15 West Street Permit# 2017-00425

This email is to serve as our response to your review of the FPE code analysis and to address all of the renovations that need to be made to bring 15 West St into compliance with city requirements. I will be addressing each of your concerns point by point below:

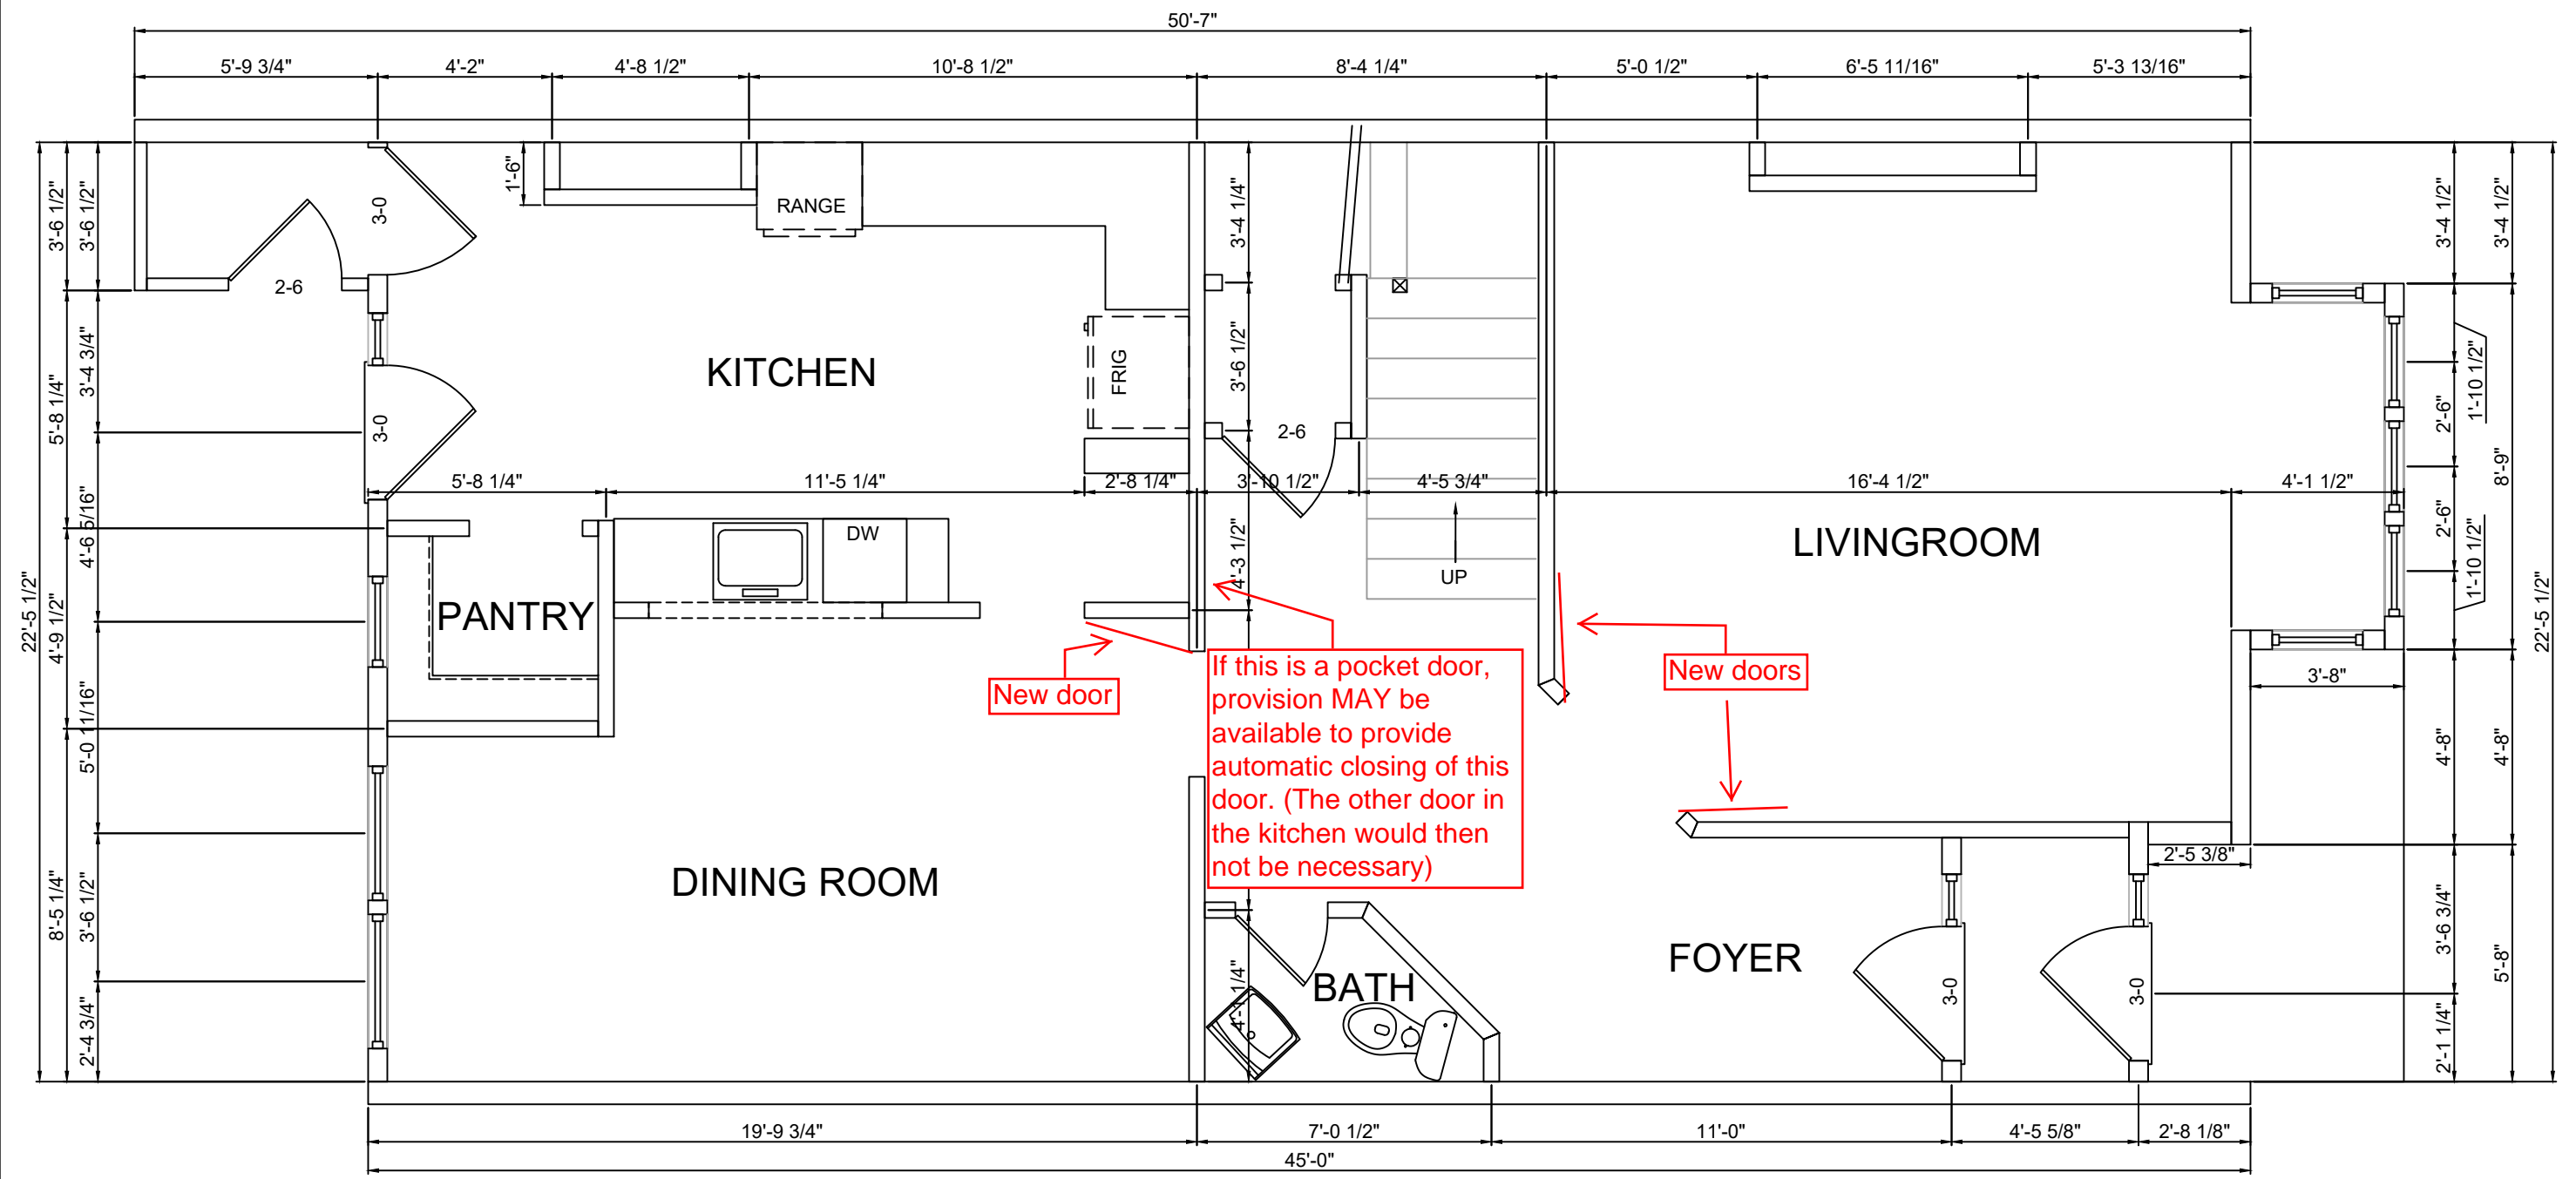
The Doors: As you wrote: "I will allow the handrail to remain as is and the stairway to remain open only if all the doors recommended by the FPE are added including the living room and the second floor area. All of the door will be allowed to remain in the open position provided that they automatically close when any smoke detectors in there immediately vicinity of the doors activates. Additionally any existing solid door in good condition that is tight fitting shall be allowed to be used instead of a new fire rated door assembly door. "

- We have hired a contractor to complete work on the doors specified in the FPE code analysis. I have attached pictures of the FPE code analysis with the doors requiring renovation (see pages 7+8). These doors shall be referred to going forward as the Kitchen Door, Living Room Door, and Second Floor Door. Below is a description of the work to be completed by our contractor, John Getchel. Additionally our smoke and fire alarm provider will install
 - Kitchen Door: Install a fire-rated door and door jamb at the entry to the kitchen area.
 - Living Room Door: Install a fire rated door and door jamb to the Living Room.
 - Second Floor Door: Build a floor to ceiling partition wall in the hallway to the staff quarters, to accommodate a fire-rated door and door jamb.

**15 WEST STREET**  
**PORTLAND, ME 04102**  
**FIRE ALARM PLAN**

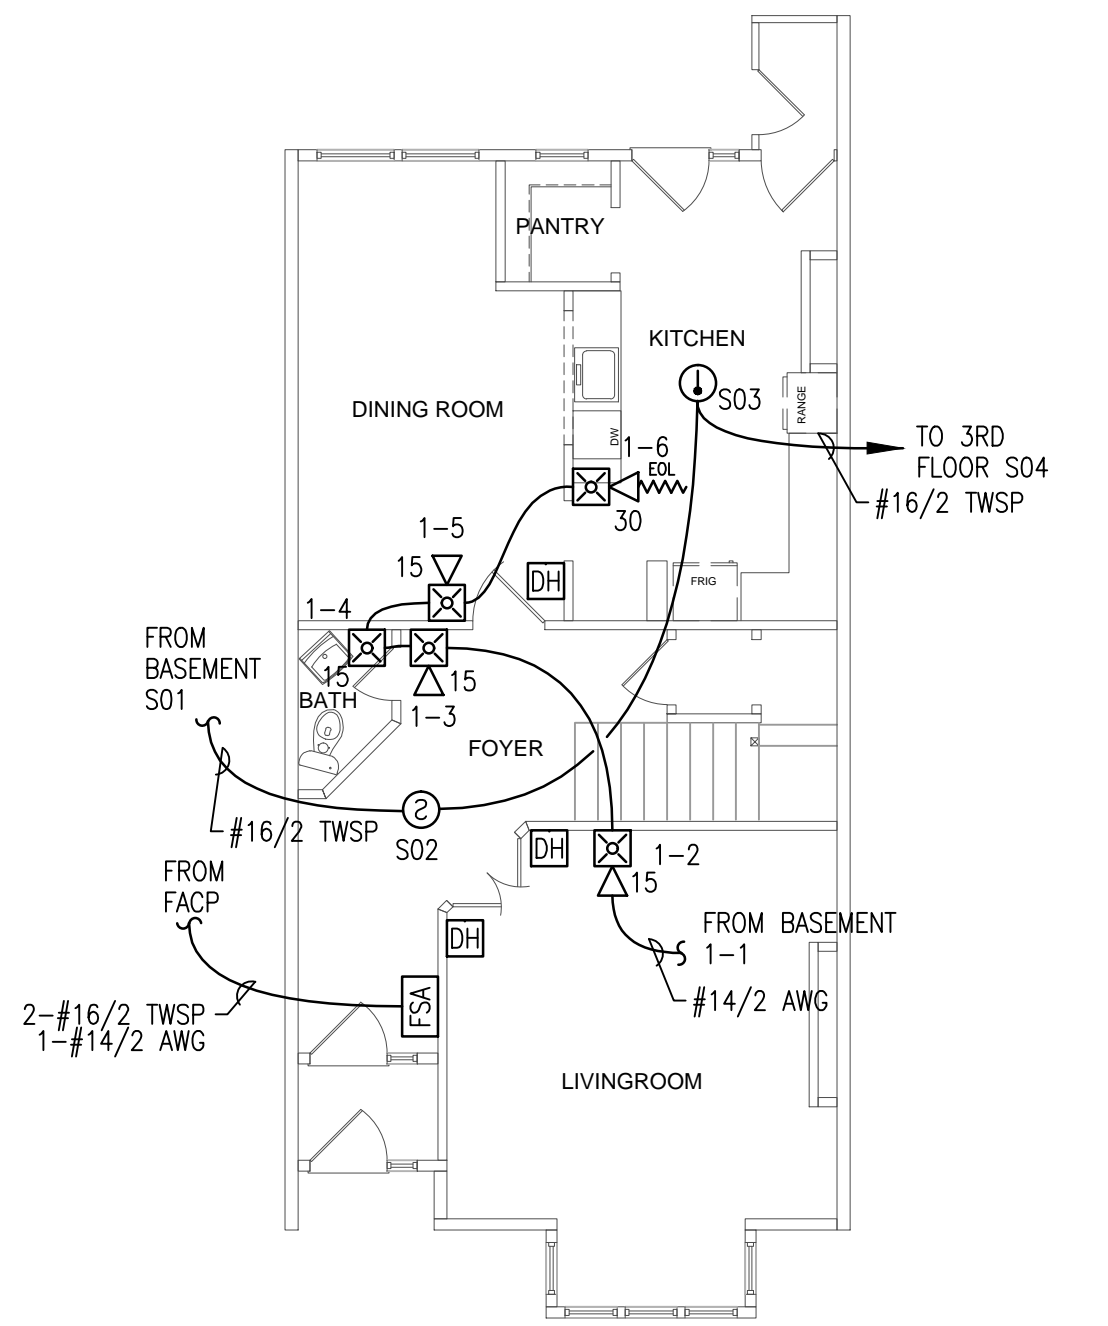
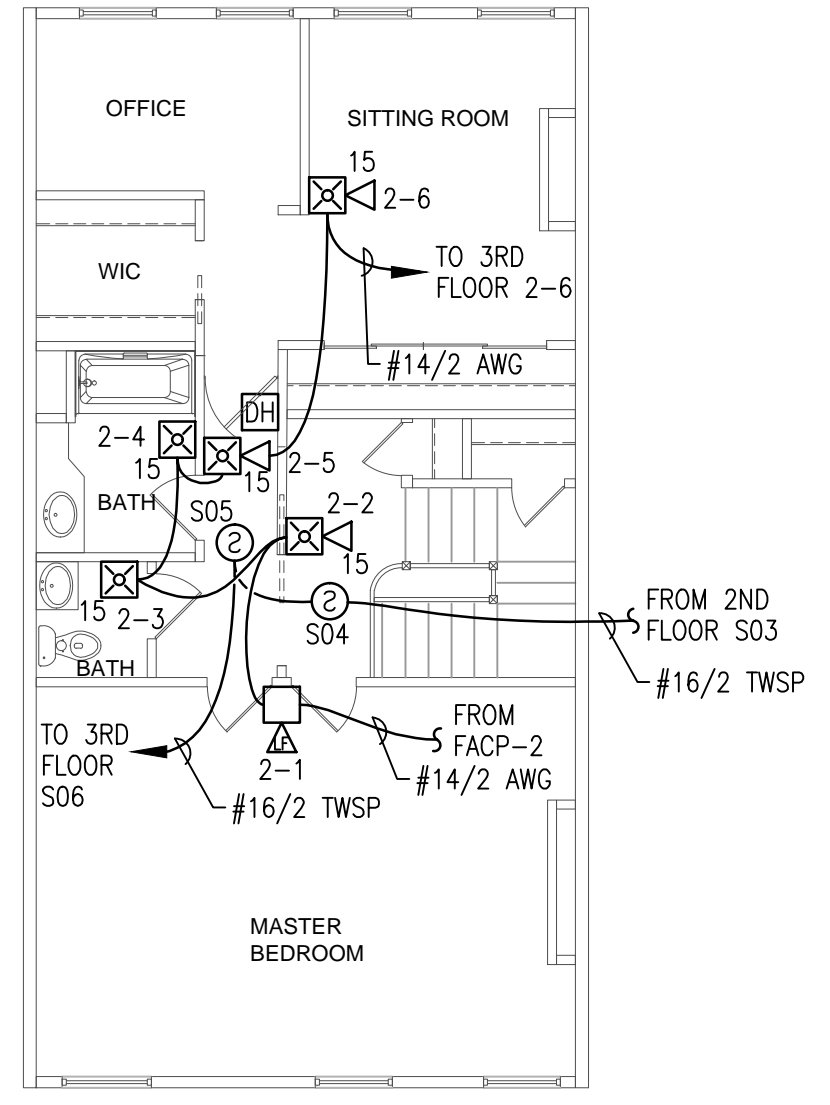
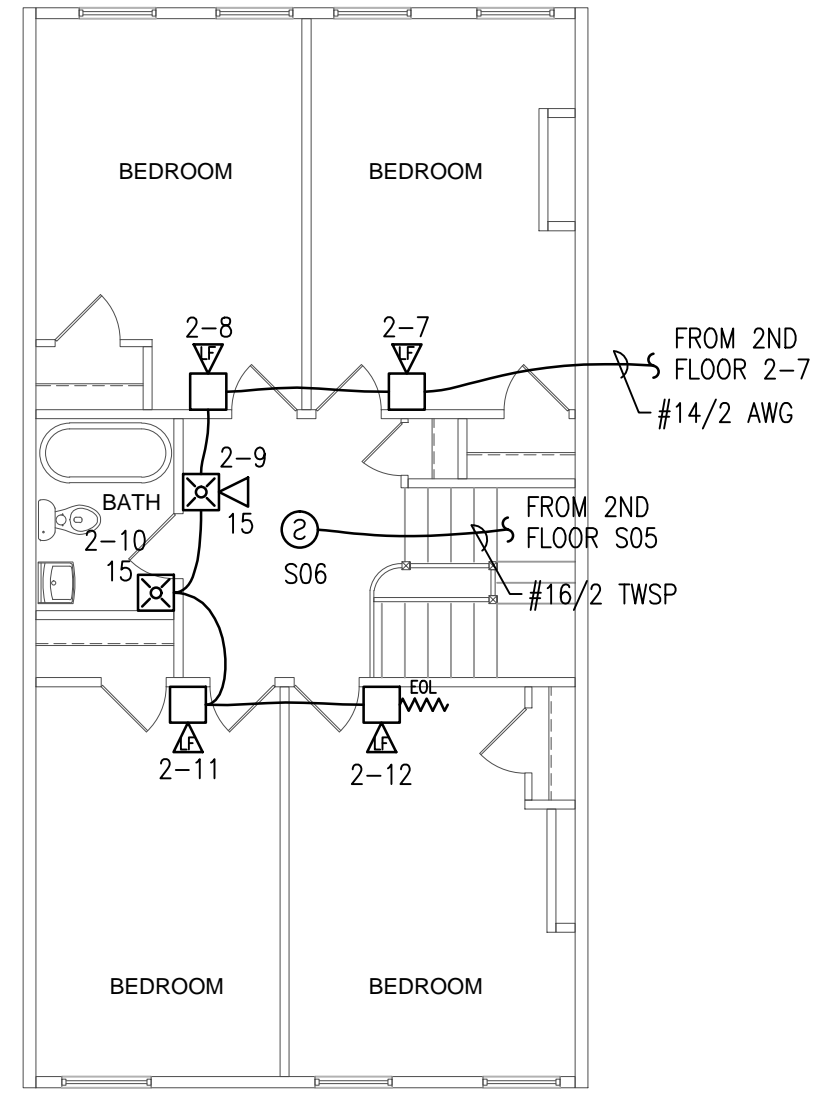
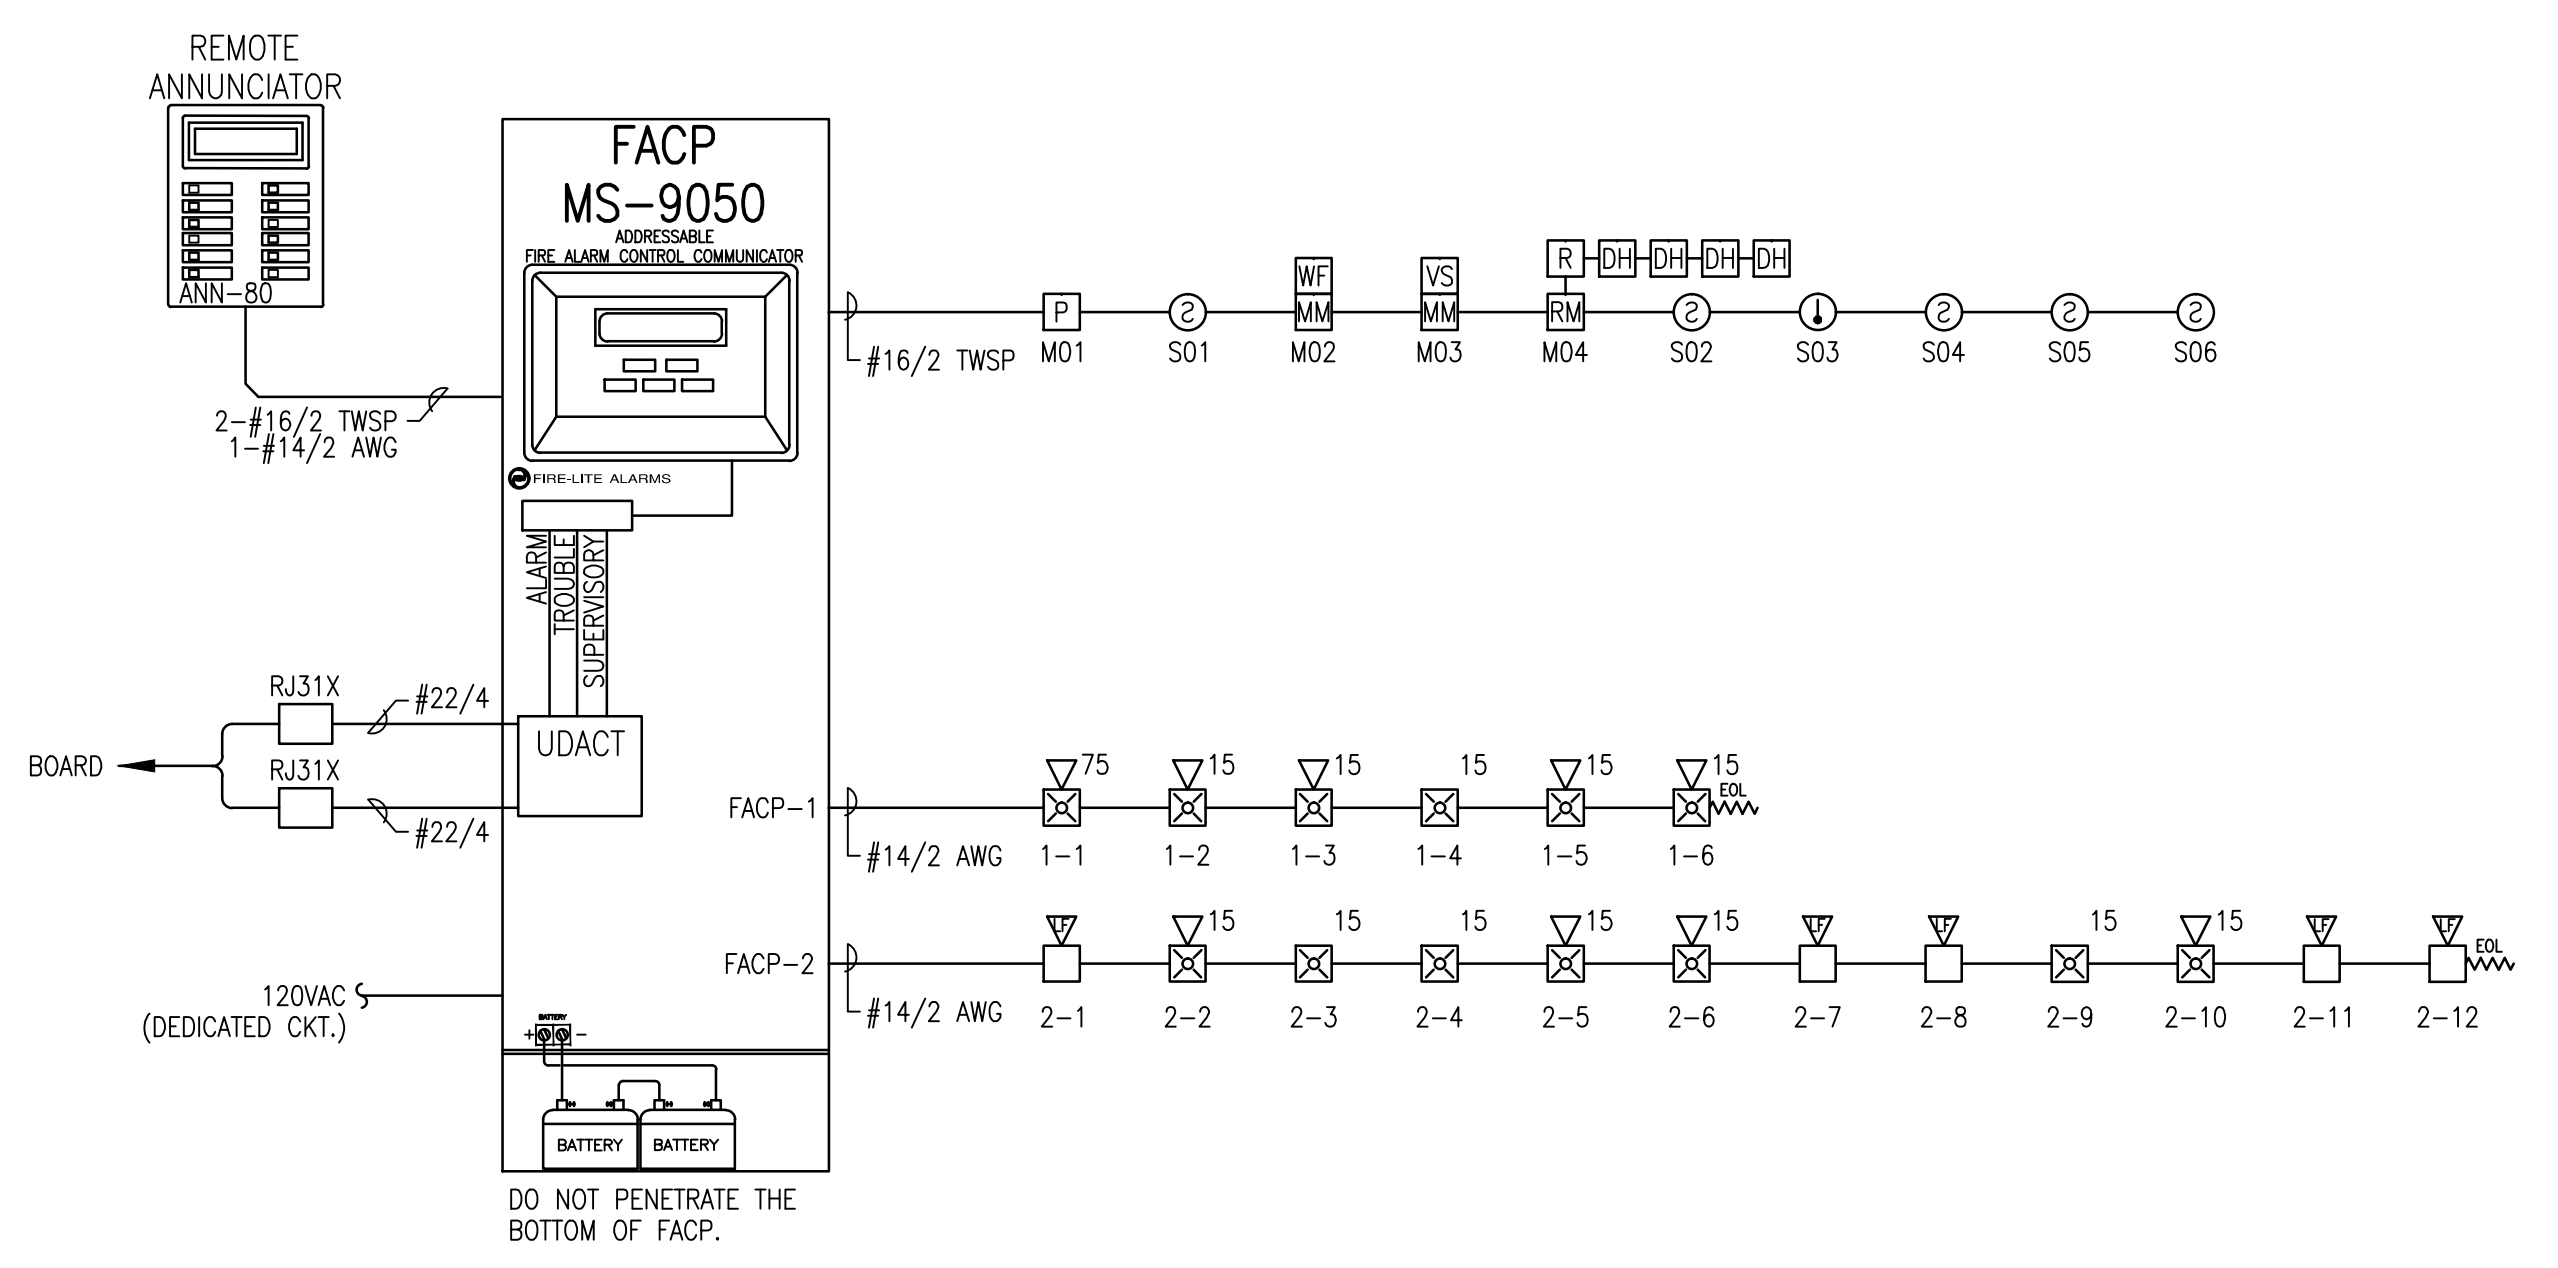
Smoke and Fire Alarm: As you wrote: "The path of egress from all area and all floors of the building shall have a monitored smoke alarm detection. All bedrooms will be allowed to have interconnected A/C powered local smoke alarms with battery backup...and that a monitored fire alarm system will be installed in the building."

- We have hired Cunningham Security to complete the smoke and fire alarm installation. He will be addressing all of the issues mentioned in the FPE code analysis as well as your concerns. Please see his plans attached and below is his description of work to be completed

- *Scope of work: "Upon review of the code analysis from Triangle Fire Consultants dated 6-8-2017 as well as the comments provided by the city of Portland after their review, we have designed a fire alarm system that we believe meets all the code requirements and the intent of the specifications provided. Our commercial fire alarm system shall consist of a central processing unit commonly referred to as a fire alarm control panel. The control panel will be located in the basement for aesthetic concerns predominantly and a fully functioning annunciator shall be located near the front door. A smoke detector shall be provided above the fire alarm control panel per requirements for NFPA 72 as a means to protect the control equipment from burning up before being able to send a signal. The fire alarm control panel shall monitor the functions of the sprinkler system being installed by the means of monitoring modules as separate addressable points on the system. The code analysis requires the installation of smoke alarms and carbon monoxide alarms on every level of the house in all of those locations as identified by applicable codes. It requires that they be powered by the building power, battery backed up and interconnected. It does not require that those alarms be monitored by the fire alarm system. The city, however, is requiring that paths of egress be covered by monitored smoke detectors. Since there are currently no interconnected, hard wired, battery backed up smoke or CO detectors in the building at all, we have included in our scope ALL smoke and CO detectors required by all authorities having jurisdiction. In addition to the above, the office of fire prevention requires that fire alarm occupant notification throughout the building which shall include a combination audio, visual and audio/visual appliances throughout. This will notify all occupants of a fire alarm event or water flow event. We will also supervise the position of the sprinkler gate valve which controls the flow of water into the sprinkler system. In the event of tampering of this gate valve, a signal will be sent to the monitoring company and appropriate actions will be taken to notify the responsible parties of such tampering. It is our understanding that the requirement for smoke and/or fire separation may include the installation of certain doors and we will be providing an electronic means to hold open those doors during the normal course of business as*

well as electronically release those doors in the event of a fire alarm activation. Lastly, we shall be providing a manual means to activate the fire alarm system in the basement and at each exit of the building."
